Jeremy Bach  
3410 Wilson Creek Road  
Ellensburg, Wa 98926

Today I am adding comments to the record regarding 3BR custom cuts slaughterhouse/feedlot project. In this document I will be detailing comments regarding the letter for mitigation plan and the most current SEPA.

## **COMMENTS ON (REVISED) SEPA APPLICATION FROM 4-4-23**

Drawing file: CU-23-00001 3 BR Custom Cuts / CU-23-00001 3 BR Custom Cuts - Site Plan (REVISED APPLICATION) 4-4-23.pdf

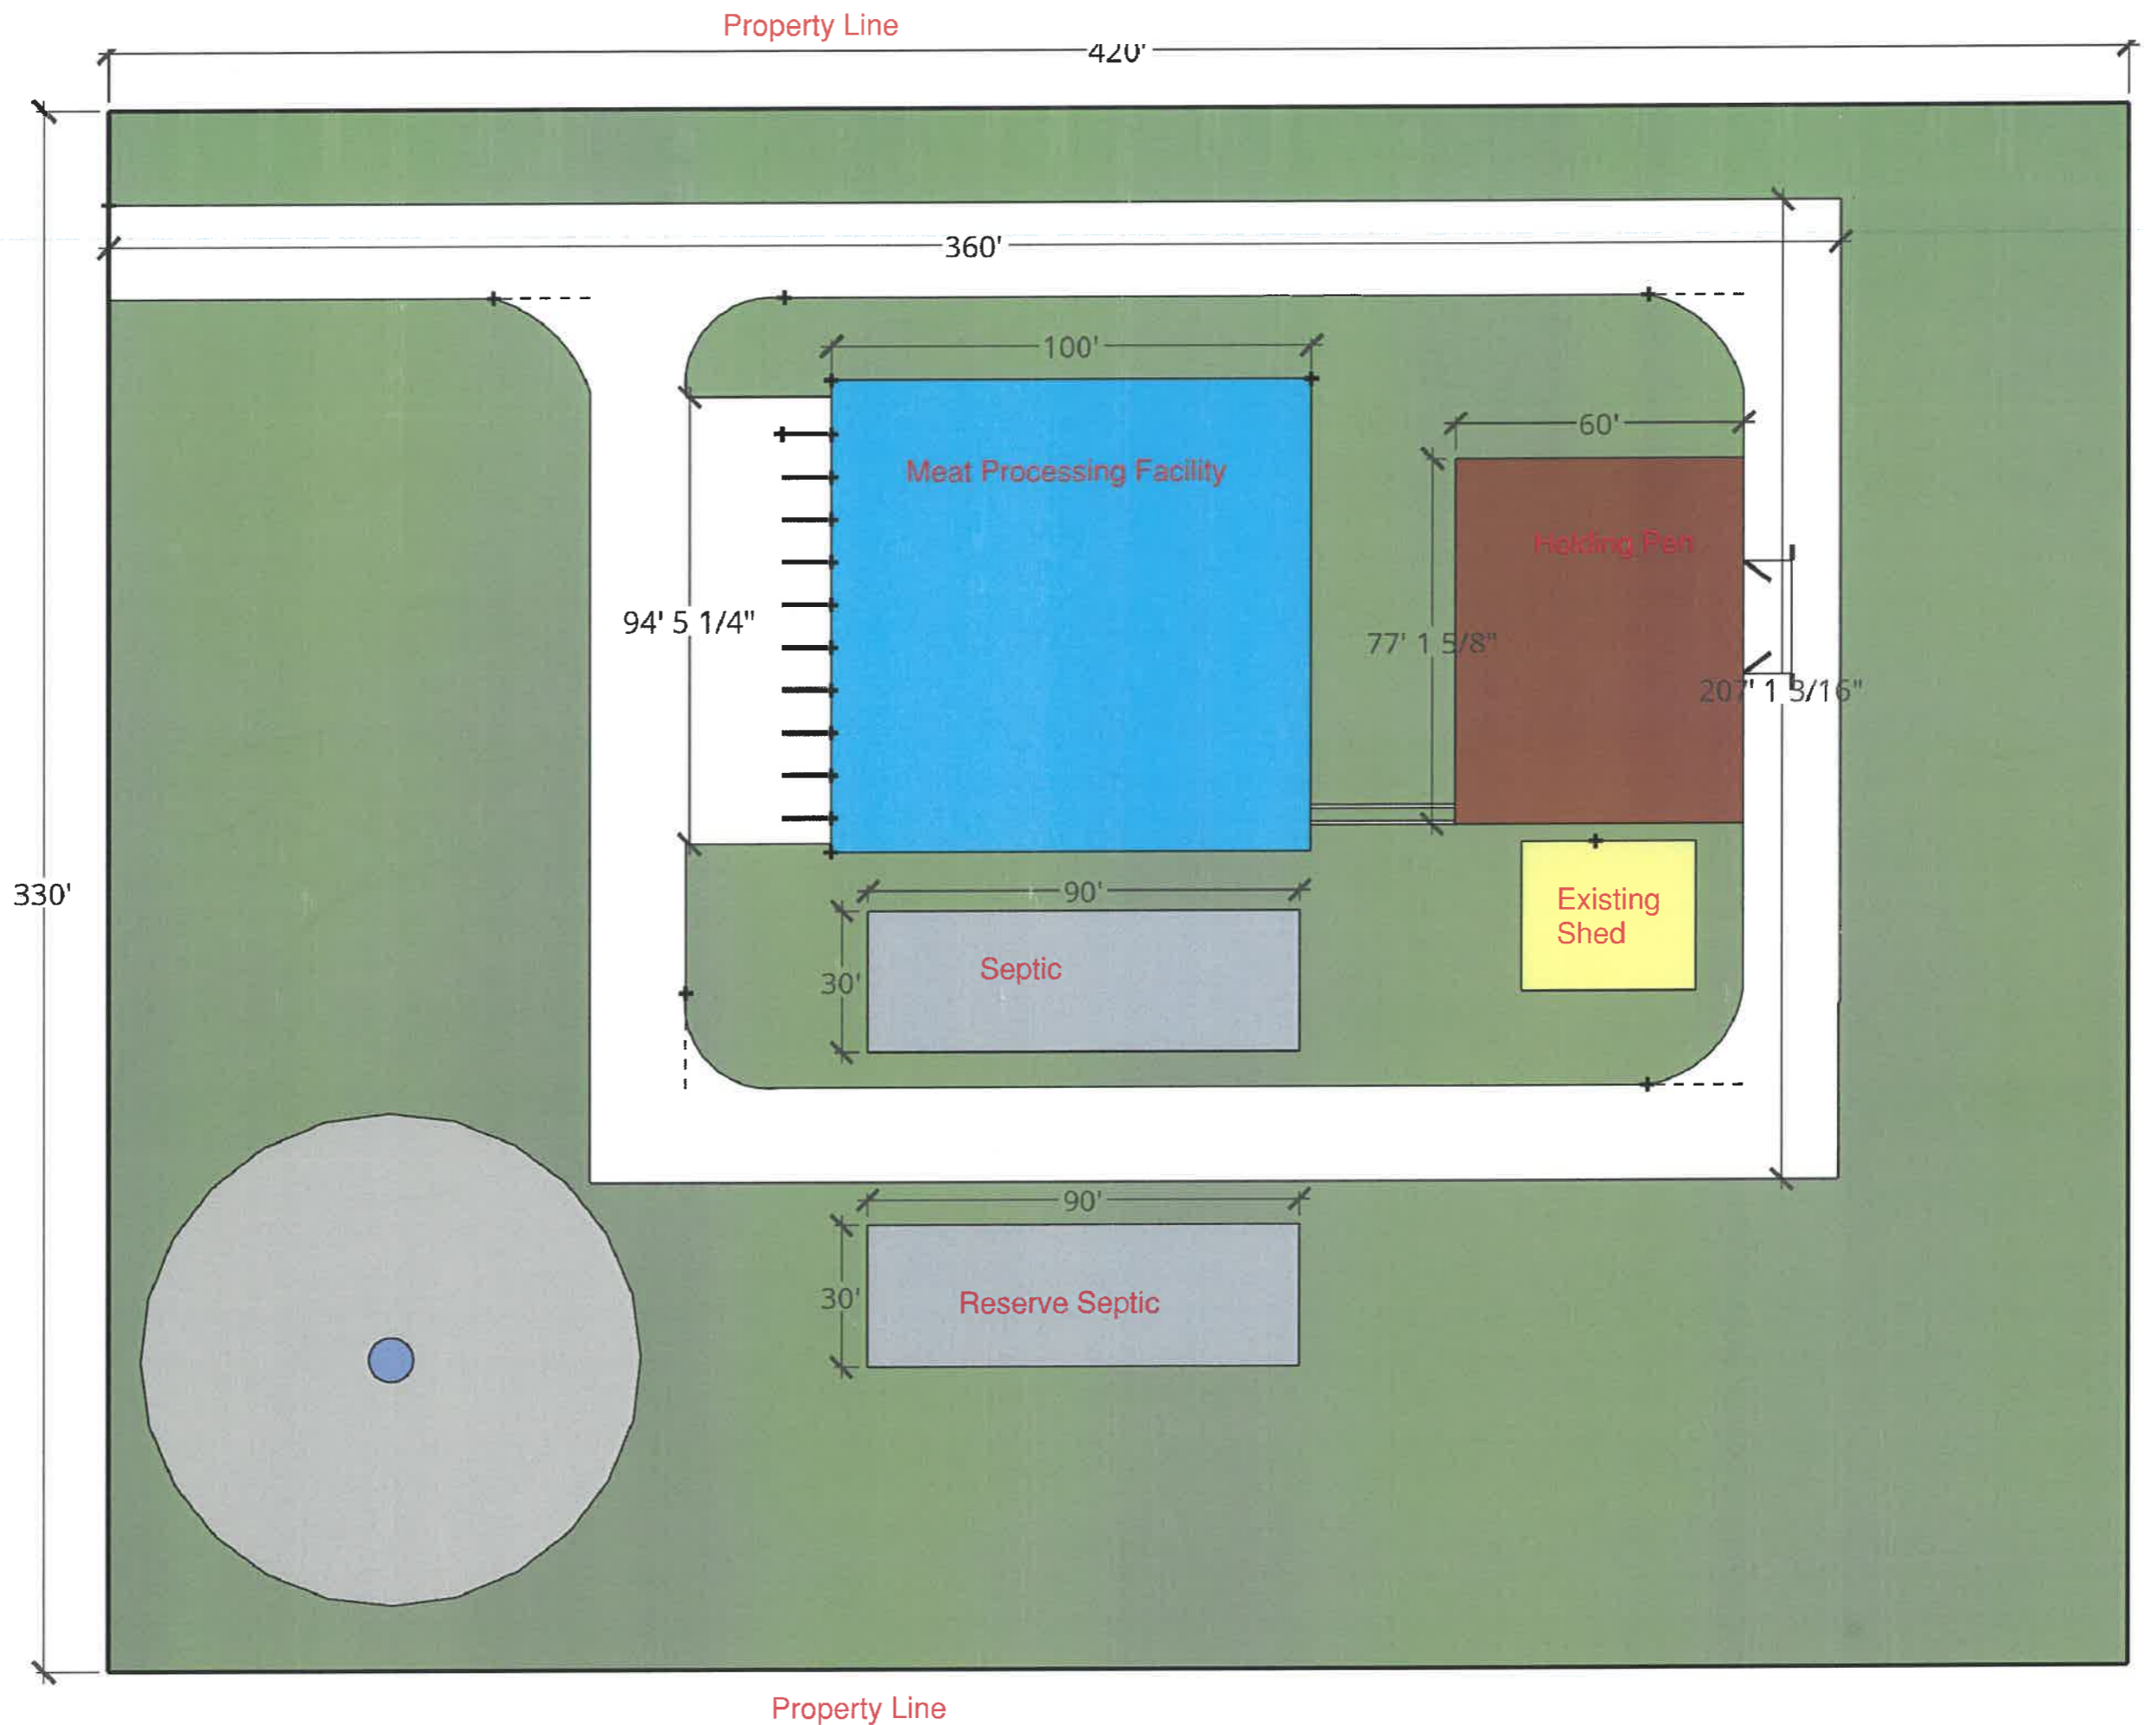
The current site plan has the holding pens and facilities up gradient from the current stock well and flood area.

All the stormwater runoff, waste from the holding pens, and contaminated water from washdown facilities would have a great potential to drain towards the well and flood area draining into Wilson Creek ditch.
